Reference No:	<b>2024/62/92606/W</b>
Site Address:	Woodland Fisheries, 72, Springwood Road, Thongsbridge, Holmfirth, HD9 7SN
Description:	Erection of side extension and increase roof height
Recommending Officer:	Laura Yeadon

**DECISION – CONDITIONAL FULL PERMISSION**

## Officer Report

1 Rear Elevation (South)
1 : 50

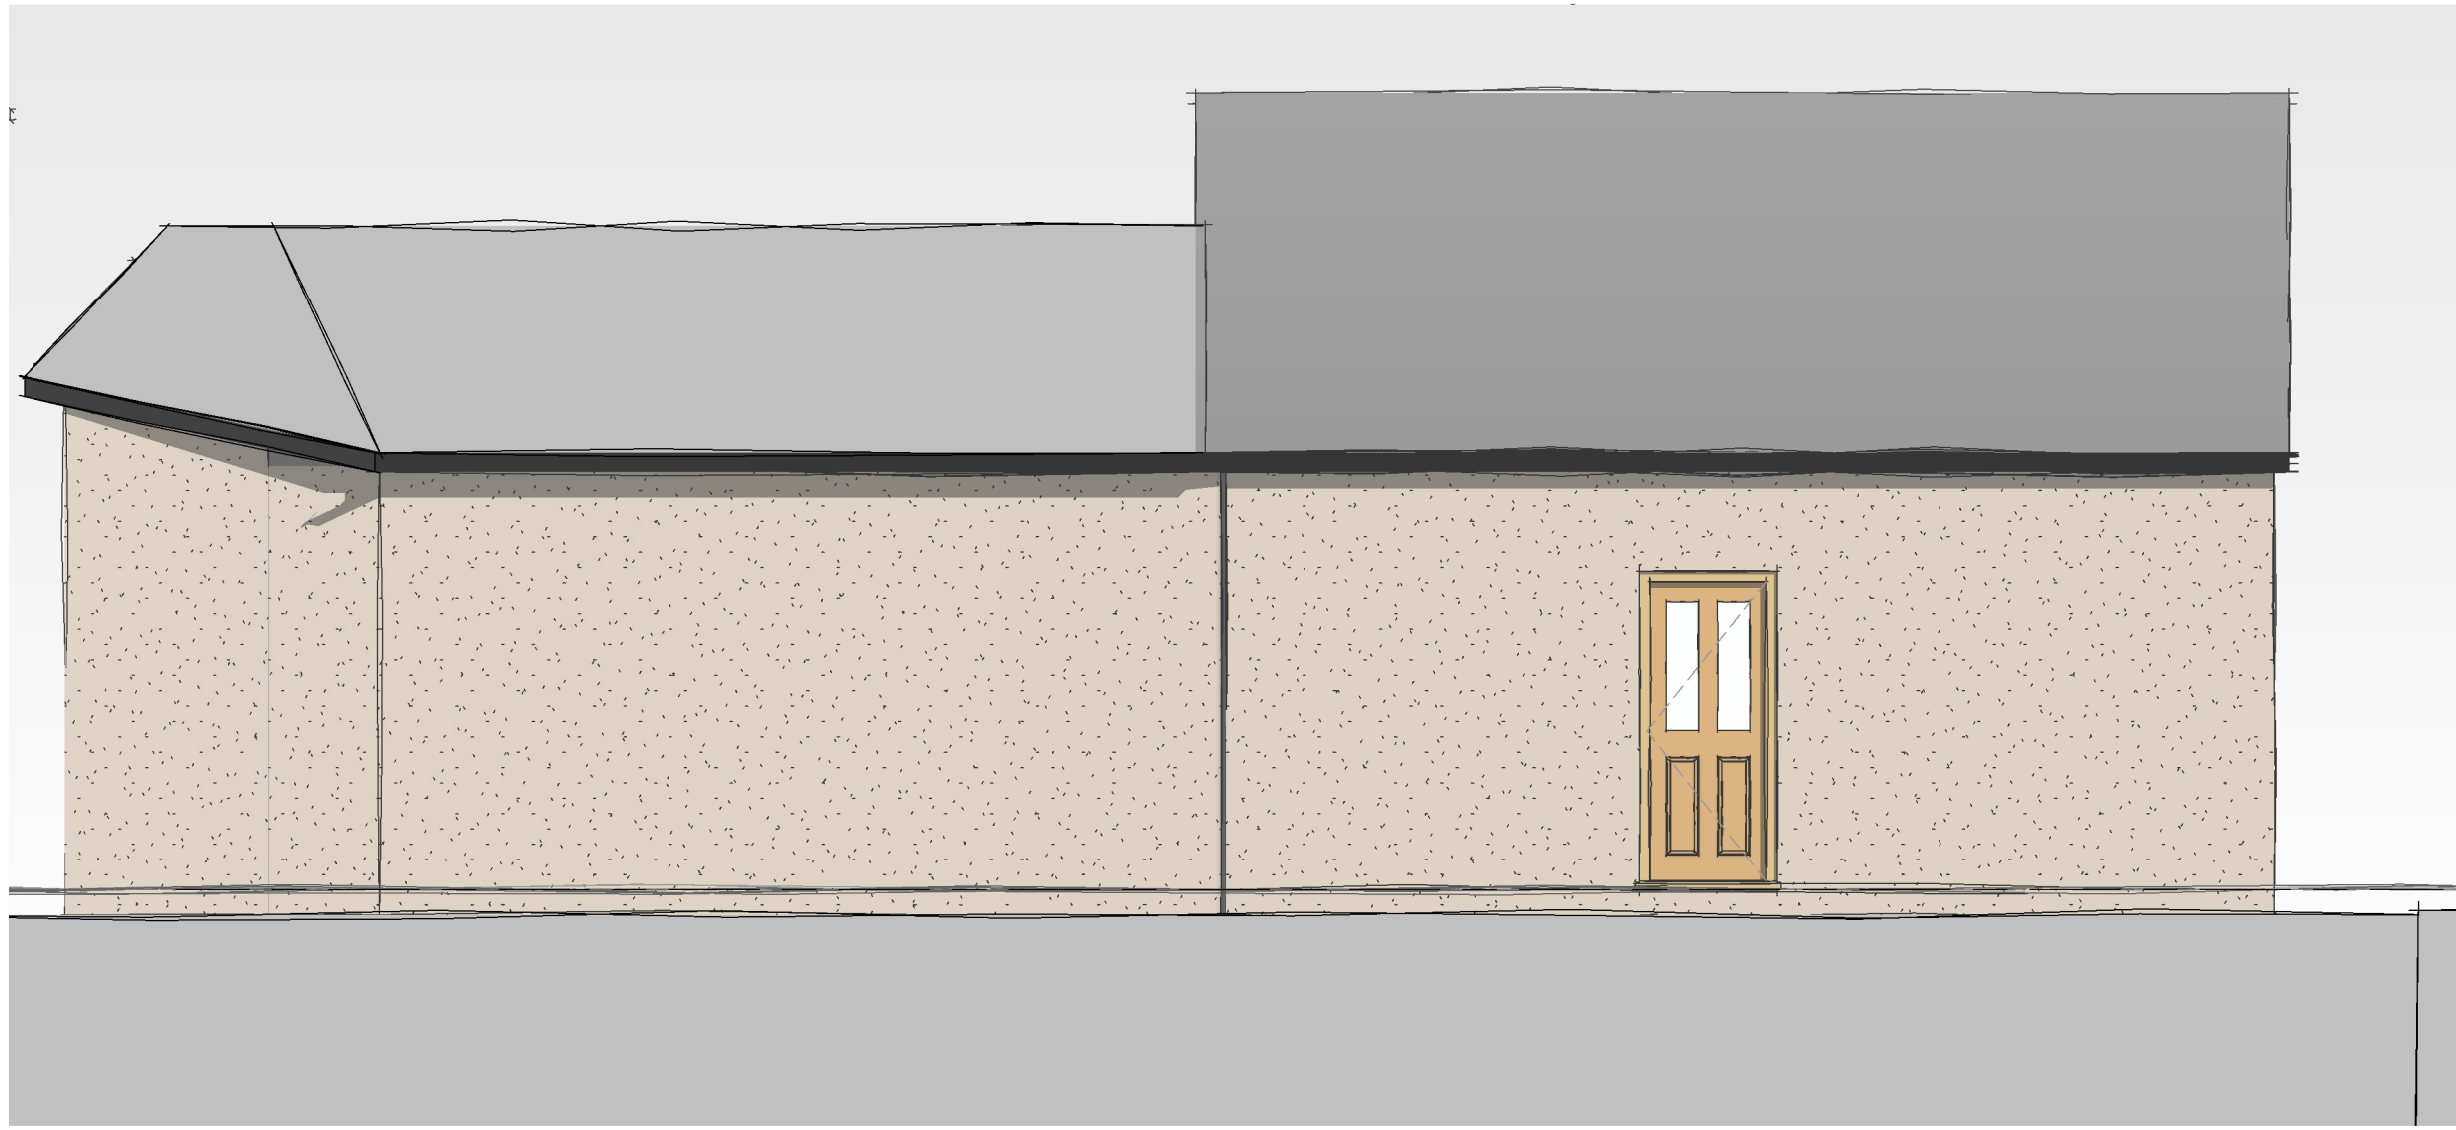
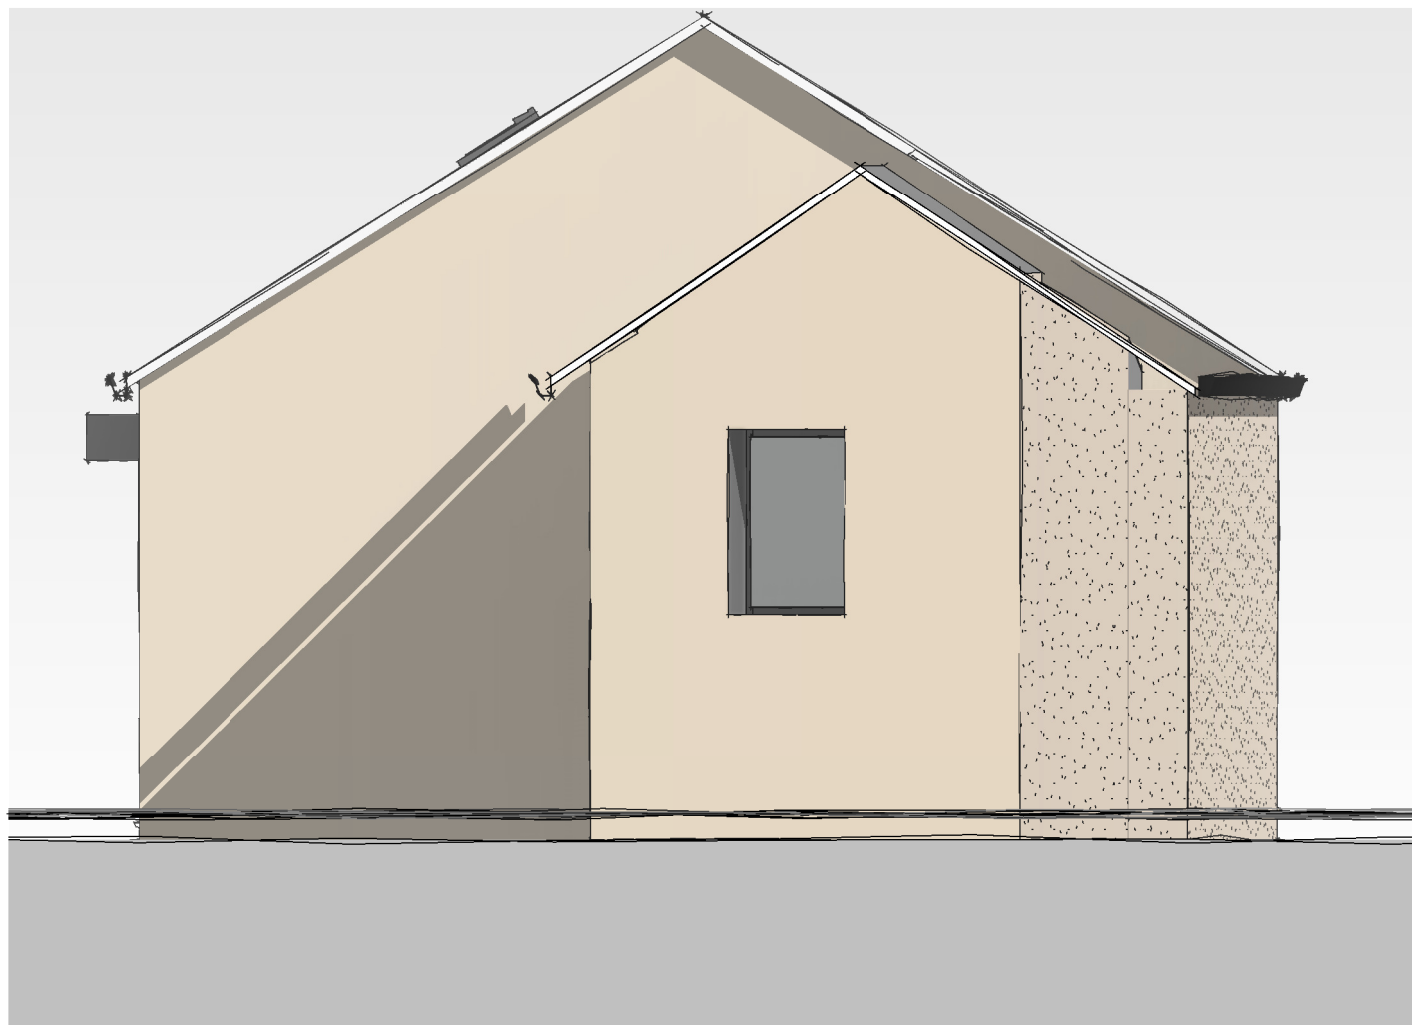
As part of the previous assessment, it was noted that the doorway which would be inserted into the rear elevation of the existing building would be removed on the submitted plans however, it was retained on both the previous and these current plans. Chapter 8 of the National Planning Policy Framework imposes a material consideration to consider the impacts of development on crime and security for promoting healthy and safe communities, which is supported by LP24e) of the Kirklees Local Plan.

In line with the previous report, Officer’s recommend that this doorway is omitted from the scheme in order to prevent access interfering with the school administration from installing replacement secure boundary fence to the rear boundary for safeguarding/security and to allow the proposal to otherwise proceed to determination. Subject to condition, this would comply with

6. Notwithstanding the submitted plans, this permission does not extend to the proposed door within the rear elevation of the existing building.

Project:	Woodland Fisheries
Drawing	Proposed Side Elevations
Scale:	1 : 50@A1
Original Drawn	MI
Original Issue Date:	
Original Checked	
Checker	
Drawing	UD-562-03
Reason For Issue:	PLANNING

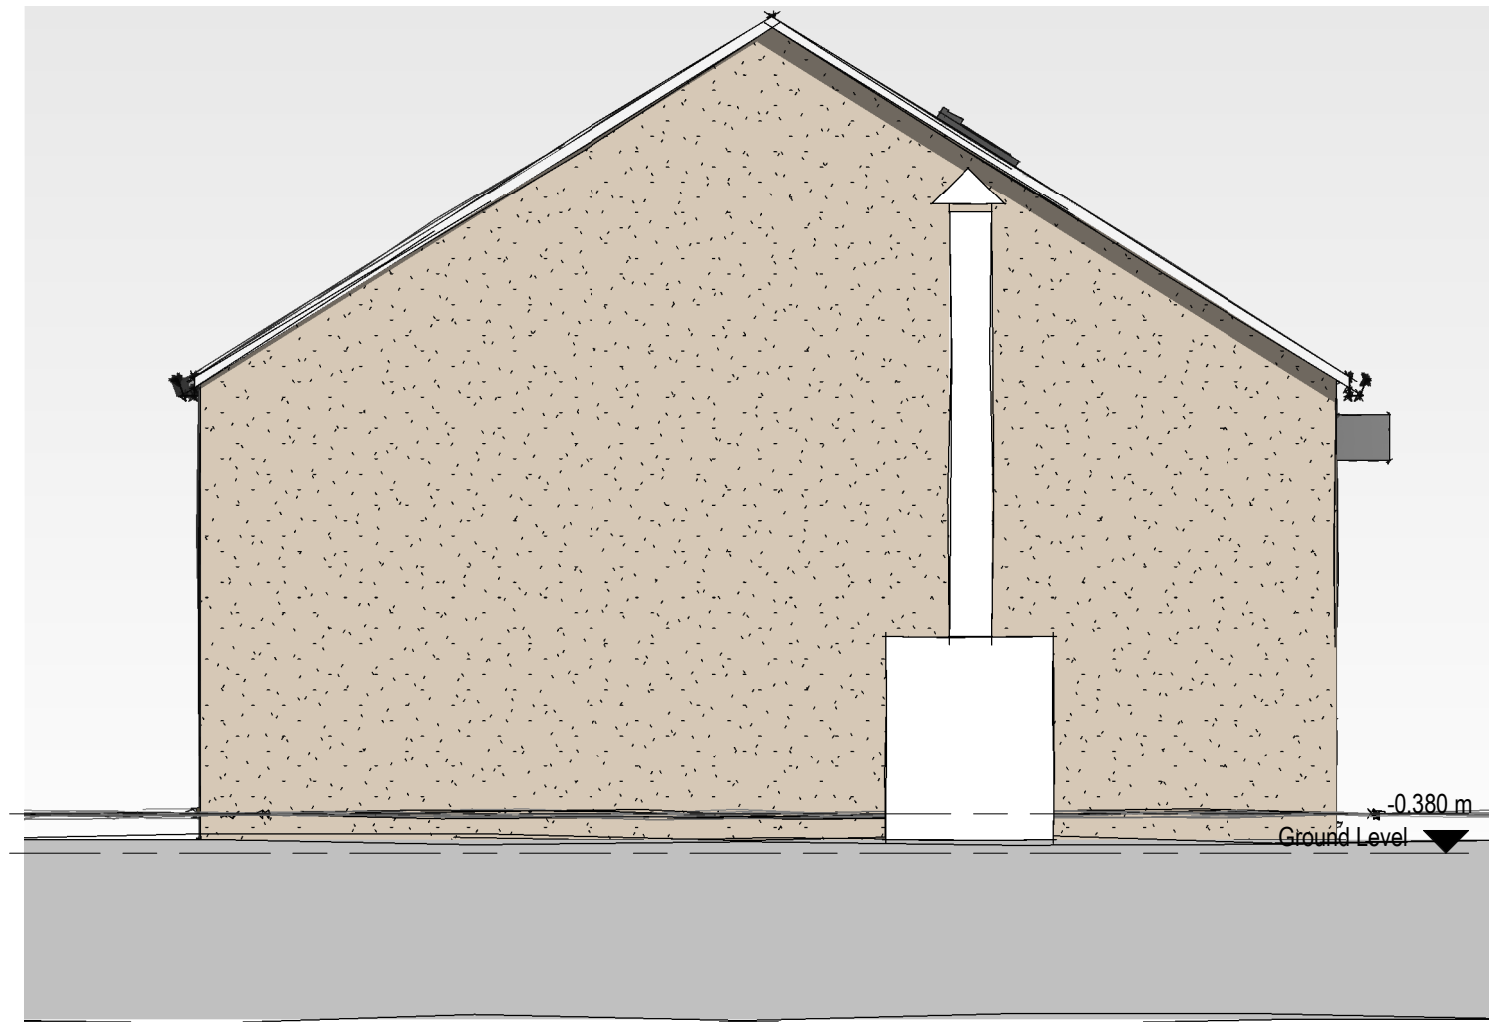
5. The development shall not be occupied until the side elevation window in the extension hereby approved has been obscure glazed to a minimum Grade 4. Notwithstanding the provisions of the Town and Country Planning (General Permitted Development) Order 2015 as amended (or any Order revoking or re-enacting that Order) The obscure glazing shall thereafter be retained for the lifetime of the development.
